Our Ref: Y/87/18/PL

**Town & Country Planning Act 1990 (as amended)
Town and Country Planning (Development Management Procedure) (England) Order 2015
Application for Planning Permission**

Development Change of use of redundant farm building & adjacent land to dog boarding kennels.
Location Rookery Farm Flansham Lane Felpham

LOCATION PLAN 1:1250

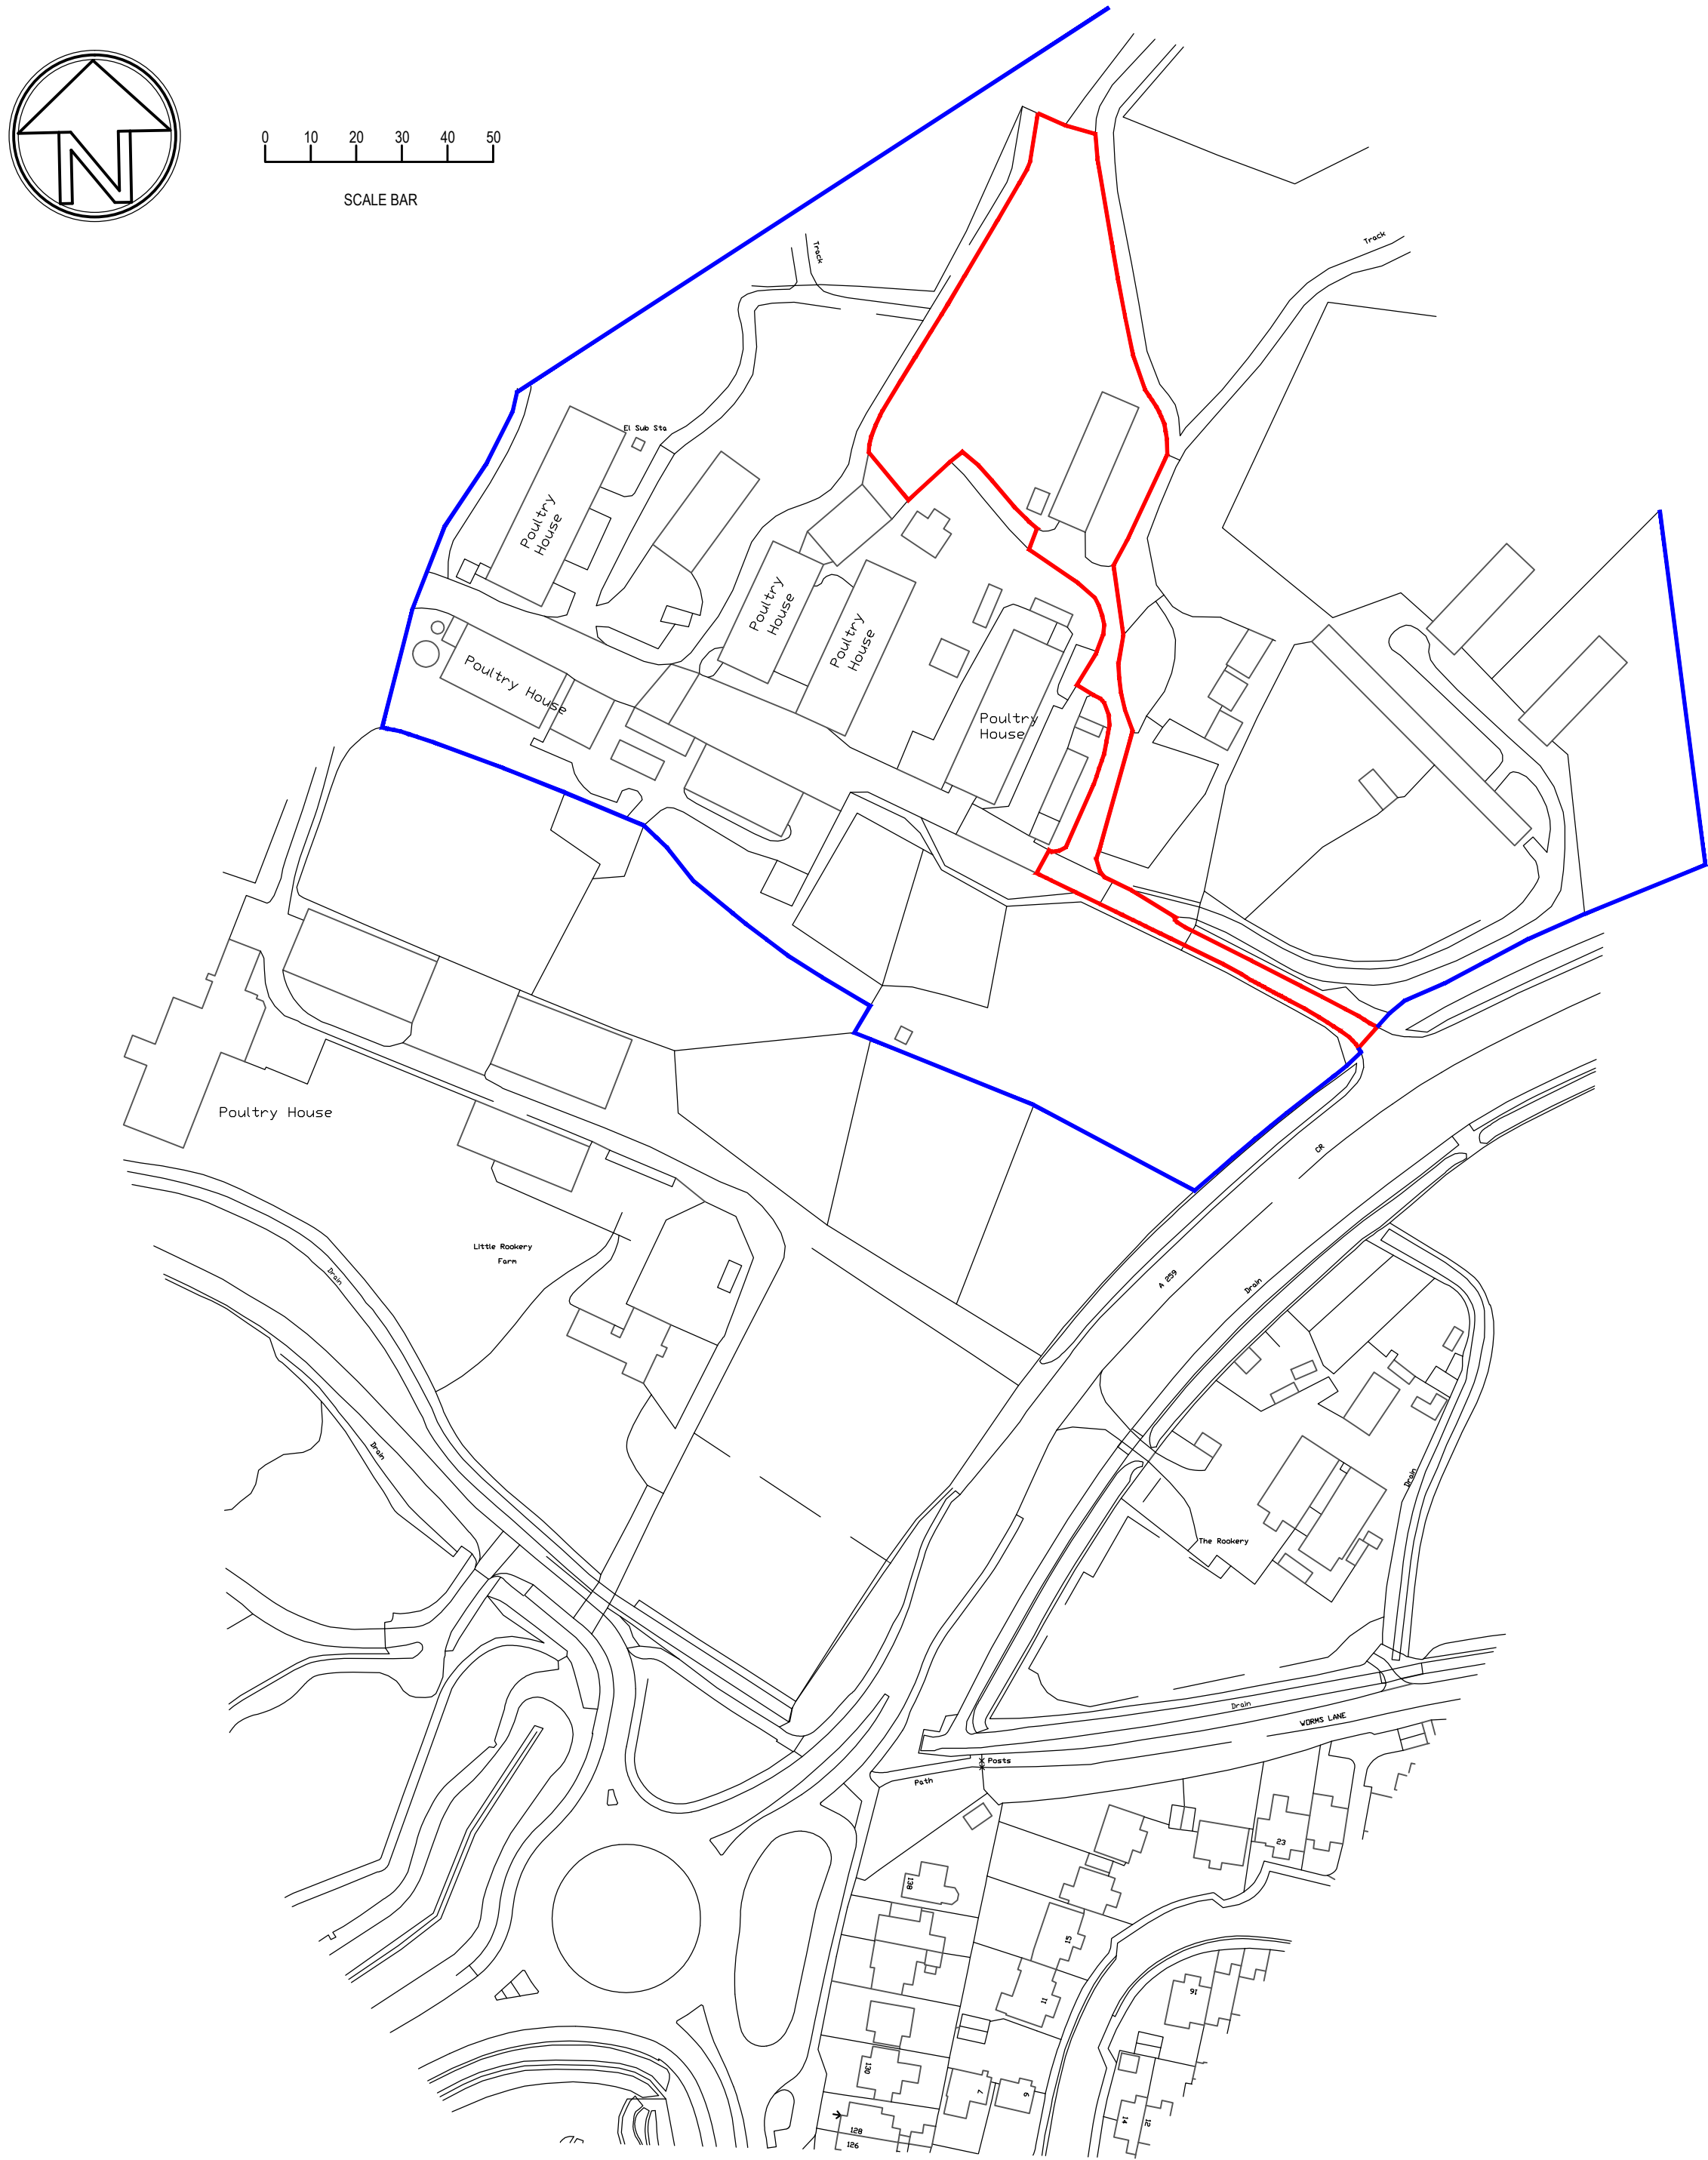
Location Plan Amend

Please provide a complete blue edge.
